# CITY OF ALBUQUERQUE

**Re: 4700 Eubank Development**  
**4700 Eubank Blvd. NE**  
**Traffic Circulation Layout**  
Architect's Stamp 10-25-22 (F21-D073)

Based upon the information provided in your submittal received 11-14-22, the above referenced plan cannot be approved for Building Permit until the following comments are addressed:

SITE PLAN

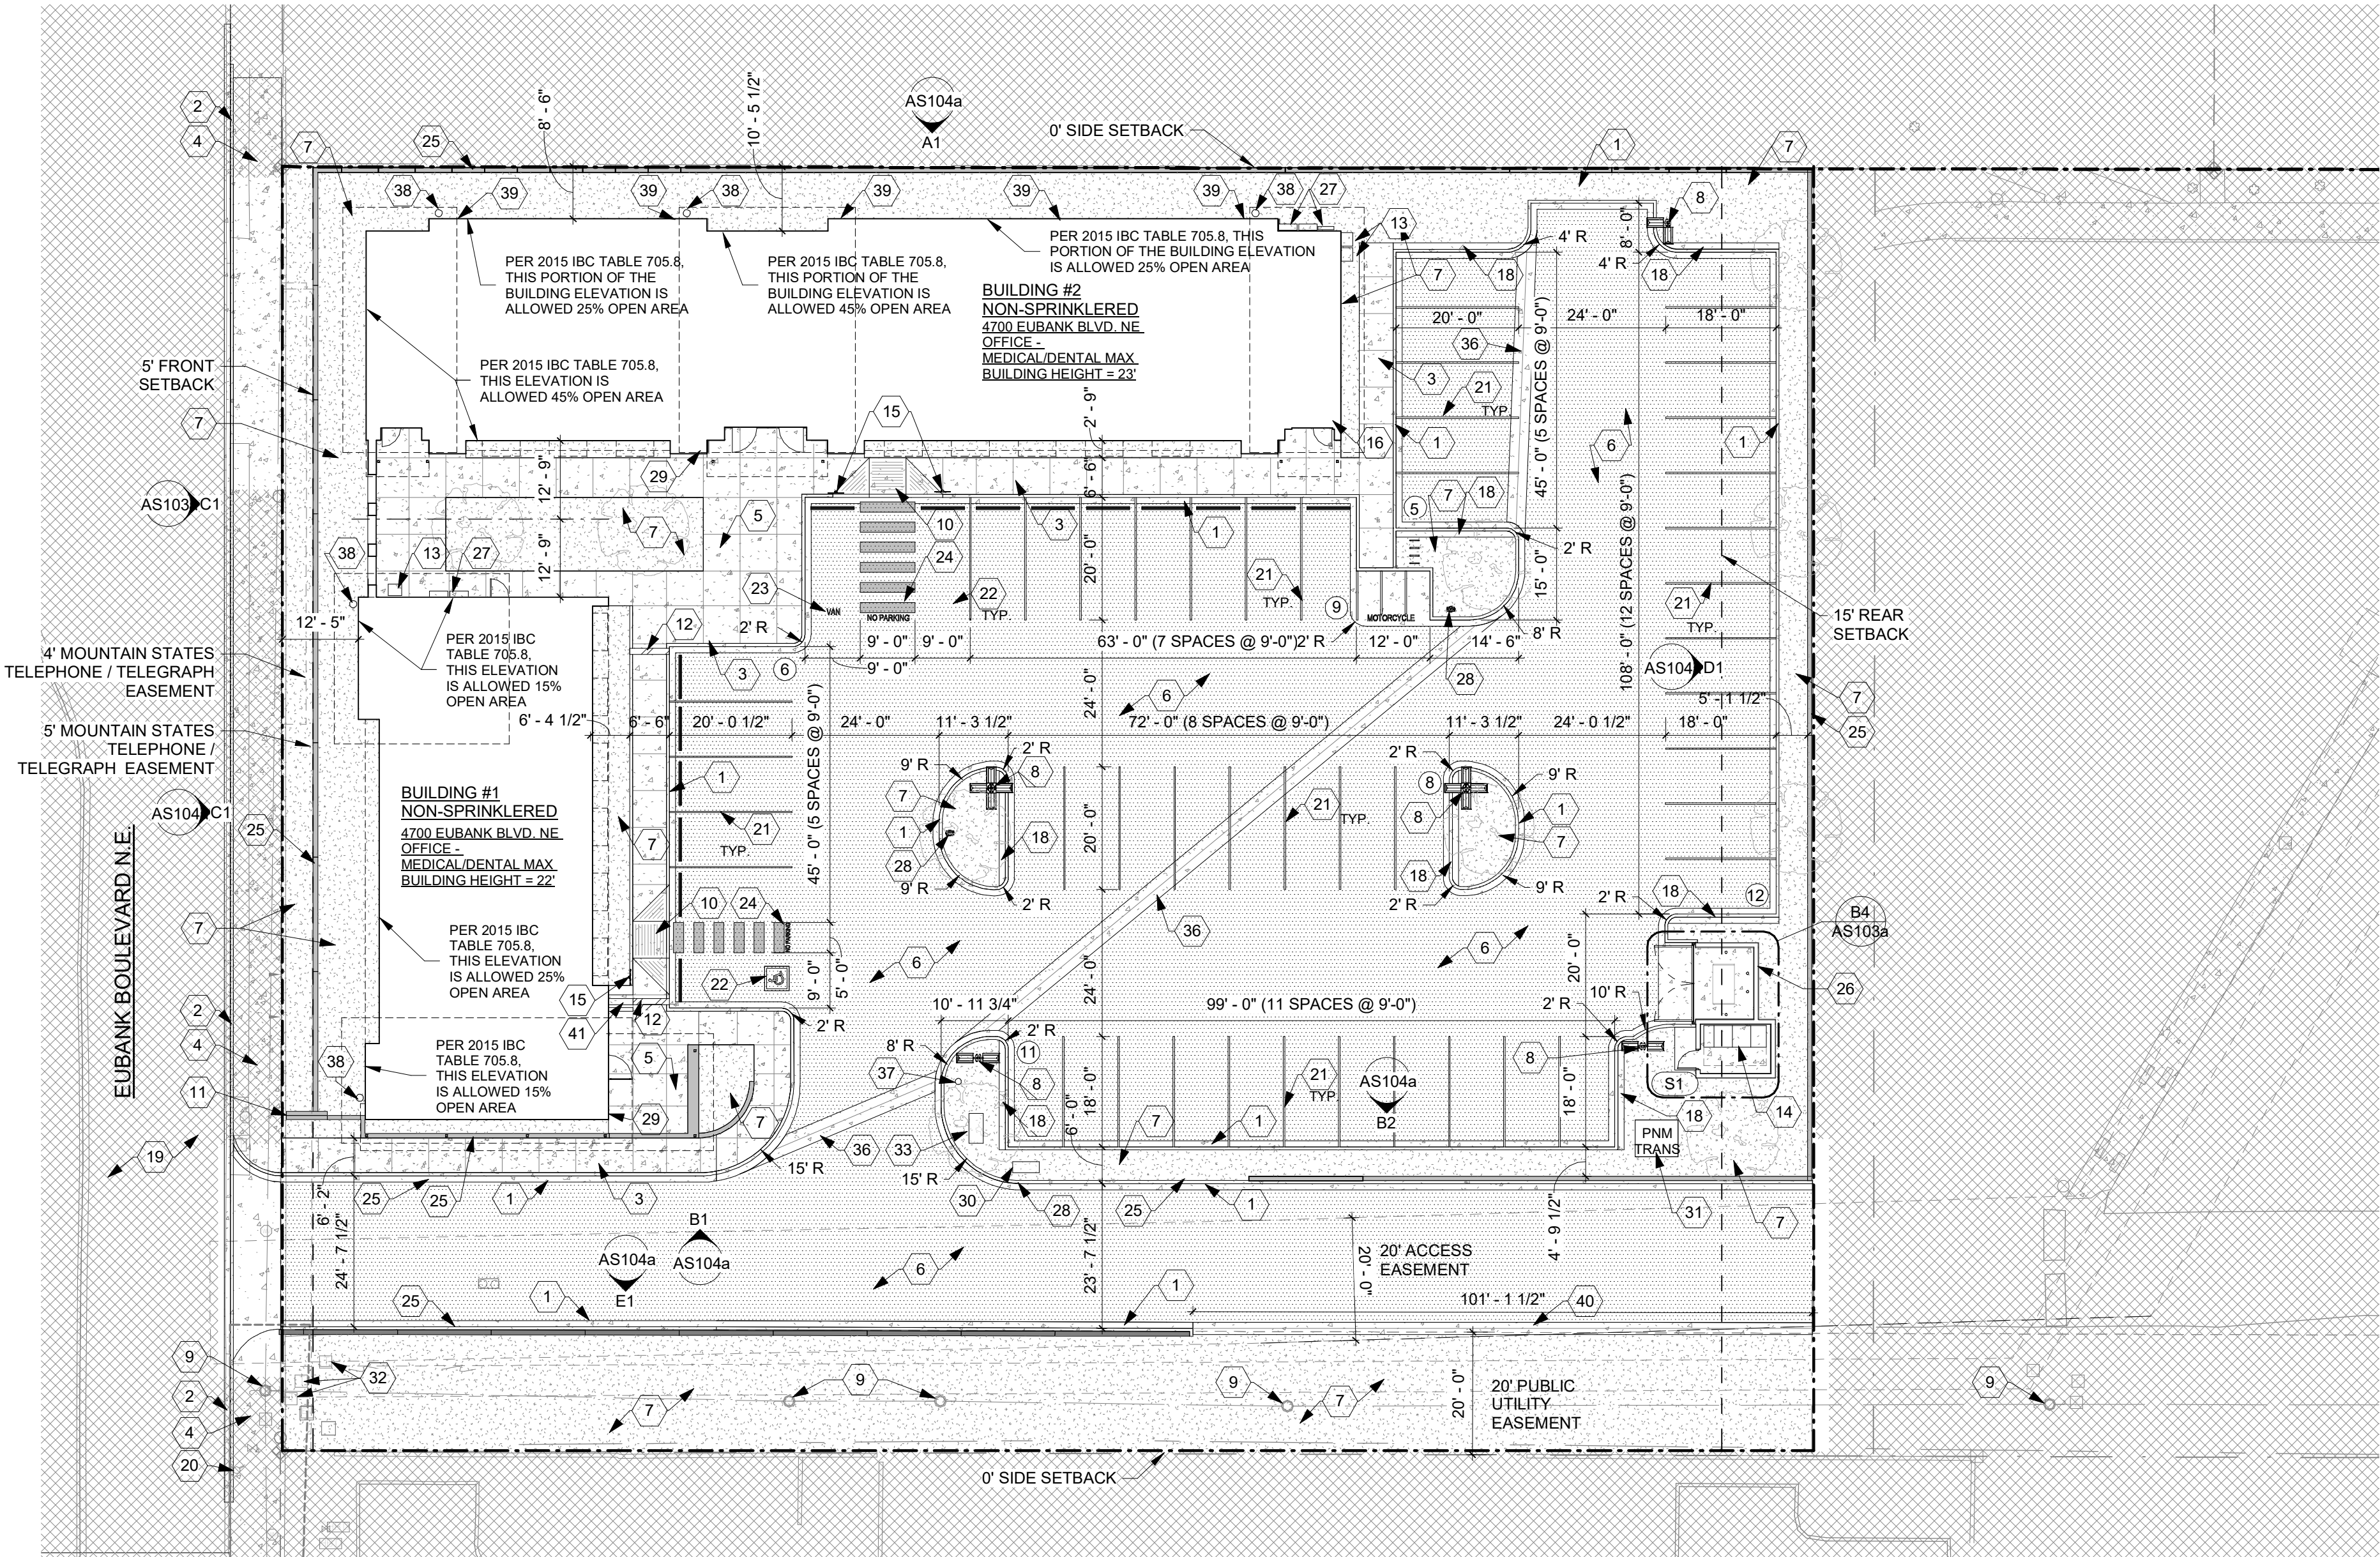
1. Please show a vicinity map showing the location of the development in relation to streets and well known landmarks.
2. Identify all existing access easements and rights of way width dimensions.

3. Identify the right of way width, medians, curb cuts, and street widths on Eubank Blvd. NE.
4. Driveway access off Eubank Blvd.: this access need to be built per COA std dwg 2426, and radius need to be provided. Radius for delivery trucks, fire trucks, etc. is 25 ft. or larger.

5. Key note 10: Provide details for the interior ADA ramps, or reference COA std dwg.
6. Key note 16: Please revise the site plan because key note 16 is referring to the building and it should be referred to the Bike Rack. Also, please provide Bike Racks' details.

7. ADA curb ramps on the City Right of Way must be updated to current standards and have truncated domes installed.
8. Motorcycle parking spaces shall be designated by its own conspicuously posted upright sign, either free-standing or wall mounted per the zoning code.

9. The pavement marking "MC" should be shown in the opposite direction for motorcycles entering the parking space.
10. Refuse vehicle maneuvering shall be contained on-site. The refuse vehicle shall not back into the public right of way. provide a copy of refuse approval.

11. Provide a copy of Fire Marshal approval.
12. Show the clear sight triangle and add the following note to the plan: "Landscaping and signage will not interfere with clear sight requirements. Therefore, signs, walls, trees, and shrubbery between 3 and 8 feet tall (as measured from the gutter pan) will not be acceptable in the clear sight triangle.

13. Please specify the City Standard Drawing Number when applicable.

14. Unused curb cuts must be replaced with sidewalk and curb & gutter. A build note must be provided referring to the appropriate City Standard drawing.
15. Add a note stating "All broken or cracked sidewalk must be replaced with sidewalk and curb & gutter." A build note must be provided referring to the appropriate City Standard drawing.
16. Please provide a letter of response for all comments given.
17. Traffic Studies: See the Traffic Impact Study (TIS) thresholds. In general, a minimum combination of 100 vehicles entering and exiting in the peak hour warrants a Traffic Impact Study. Visit with Traffic Engineer for determination, and fill out a TIS Form that states whether one is warranted. In some cases, a trip generation may be requested for determination (**Contact Matt Grush: [mgrush@cabq.gov](mailto:mgrush@cabq.gov)**).
